Planning Inspectorate  
West Midlands Interchange

12 March 2019

## **WEST MIDLANDS INTERCHANGE HIGHWAYS ENGLAND DEADLINE 1 SUBMISSION**

drawing title
fpcr SITE LANDSCAPE

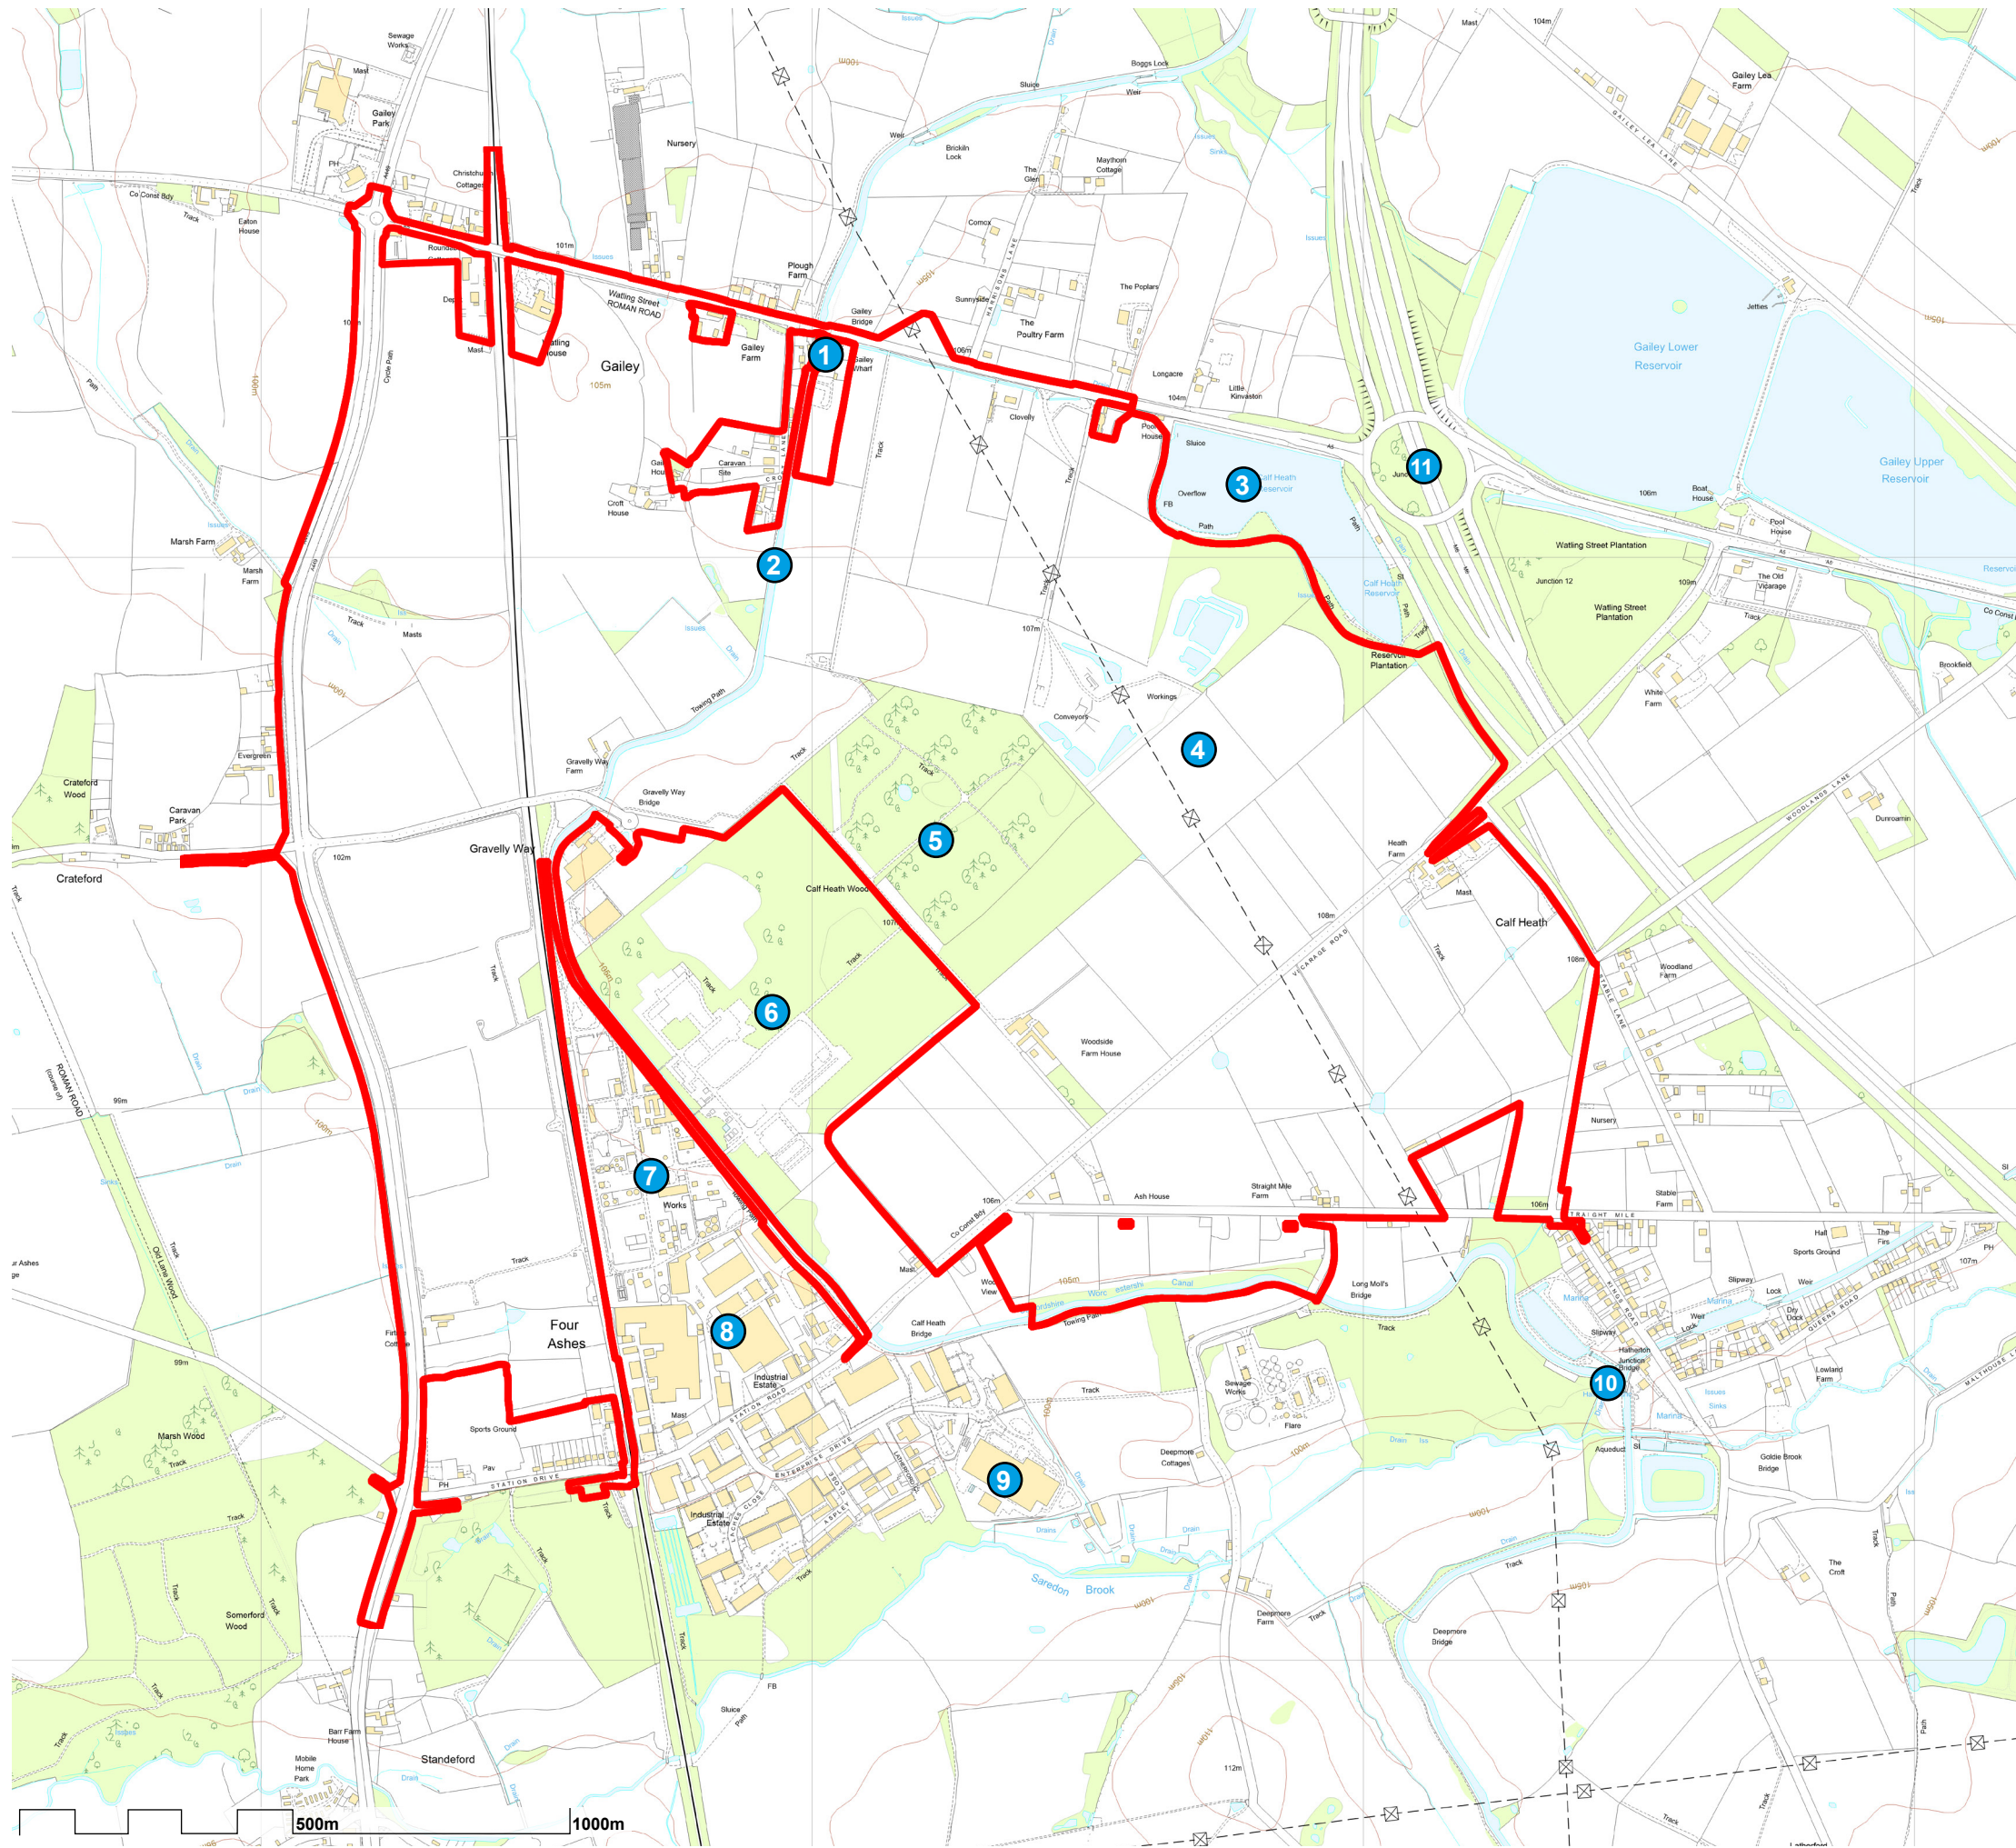
We have concerns with regards to the on-site landscaping works at the site boundary that are not currently subject to the Schedule 13 Protective Provisions, Part 2. There is potential for the site boundary landscape works to interfere with the safe operation of

the SRN. DfT Circular 02/2013 has specific policy requirements for the treatment of site boundaries that we must adhere to. Whilst these requirements have generally been complied with, we have identified in the most recent plans an issue that relate to design of earth bunds which will require further confirmation that there are no safety issues that arise. On this basis we ask that in the specific case of SRN boundary treatment approval for the designs should be secured from Highways England prior to work commencing and that Protective Provisions in Schedule 13 Protective Provisions, Part 2 apply to such proposals.

SCALE @ A3: 1:1000	CHECKED: IF	APPROVED: NJF
CAD FILE: 70001979-SK-005.DWG	DESIGN-DRAWN: RJM	DATE: April 16
PROJECT No: 70001979	DRAWING No: 70001979-SK-005	REV: A
© WSP Group Ltd

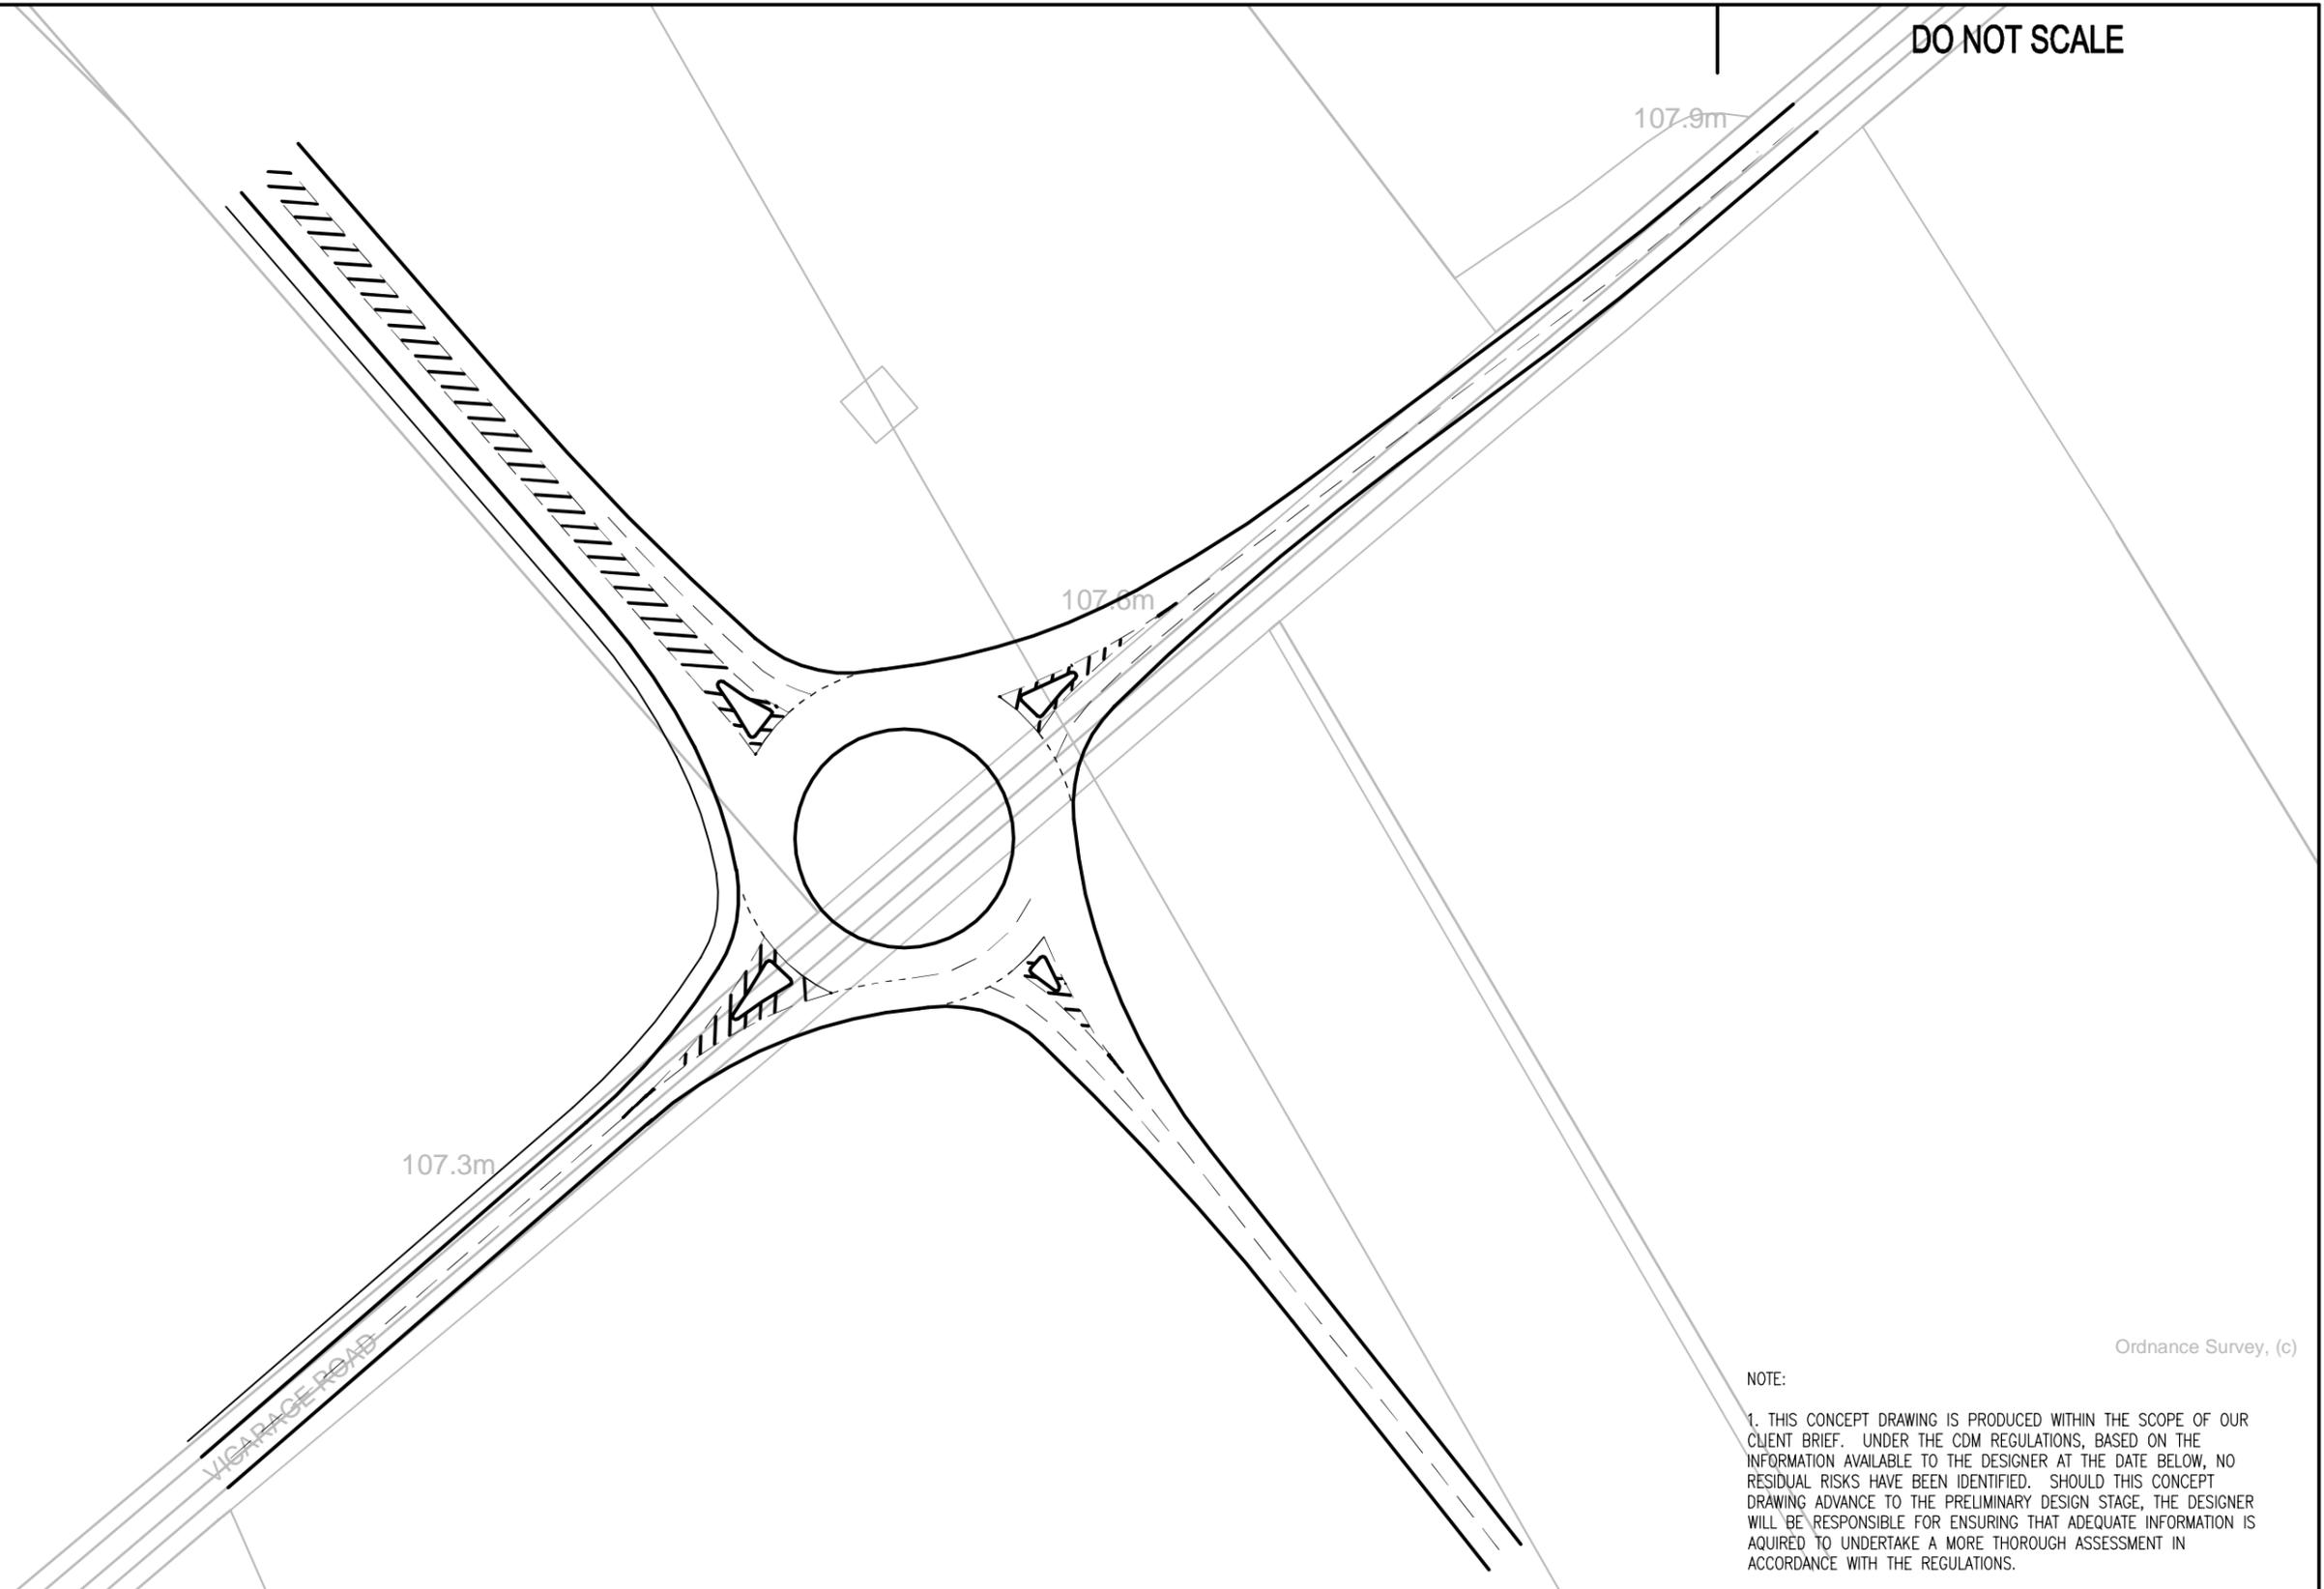
Article 13(3) provides for deemed consent to be granted for proposed new accesses after a fixed period of time. Highways England in addition to its stated position on design

approvals for accesses raised in previous correspondence has specific policy obligations imposed by the DfT in respect of new accesses on the trunk road network. DfT Circular 02/2013 contains a general presumption against new trunk road accesses being approved, although a '*graduated and less restrictive approach to the formation or intensification of use of access*' may apply on a case by case basis for a Trunk Road that is not a route of near motorway standard.

The assessment of such proposals must be made their merits and is a matter for Highways England regarding the core function of the network and safety of such proposals. Any requirement to deviate (depart) from this policy are not within Highways England's gift (being under DfT control) and such the principle of deemed consent forms a direct challenge to government policy which is not a matter for this DCO or this examination.
